Subject: Response To Application Number LU/284/19/PL at 1A &1B Northway Road Littlehampton BN17 7JX

TO:	Arun District Council FAO: Anita Gardner
FROM:	WSSC - Highways Authority
DATE:	7 October 2019
LOCATION:	1A & 1B Northway Road Littlehampton BN17 7JX
SUBJECT:	LU/284/19/PL 2 No semi detached 3 bed houses
DATE OF SITE VISIT:	n/a
RECOMMENDATION:	Advice
S106 CONTRIBUTION TOTAL:	n/a

site & block plan tp782/09

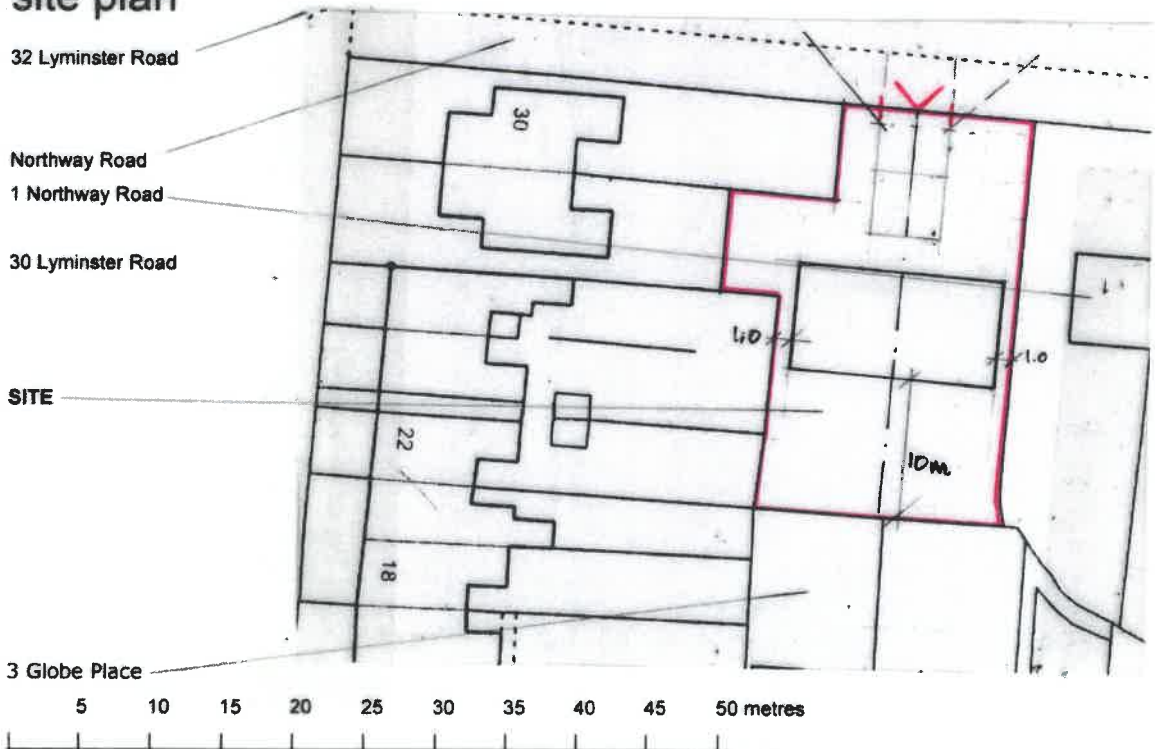
Our local mapping shows a street lighting pole within the site frontage. This has not been demonstrated on any of the proposed plans and it may be necessary to be relocated to allow the construction of the shared access. These relocation works must be undertaken at the expense of

Parking provision of 2 spaces per dwelling as stated in the application form is proposed for the new dwellings; however these have not been demonstrated on the proposed plans. This is anticipated to be a sufficient parking provision for a development of this size and location. The hardstanding area along the site frontage has sufficient spaces for two bay parking spaces considering Manual for Streets (MfS) requirements for minimum of 2.4 x 4.8 m per space. Any overspill visitor parking could be accommodated on street. The Local Planning Authority (LPA) may wish to consider the impact of the likely on-street parking from an amenity point of view.

The applicant is advised to contact the operator of the street lighting pole to organise the relocation works.
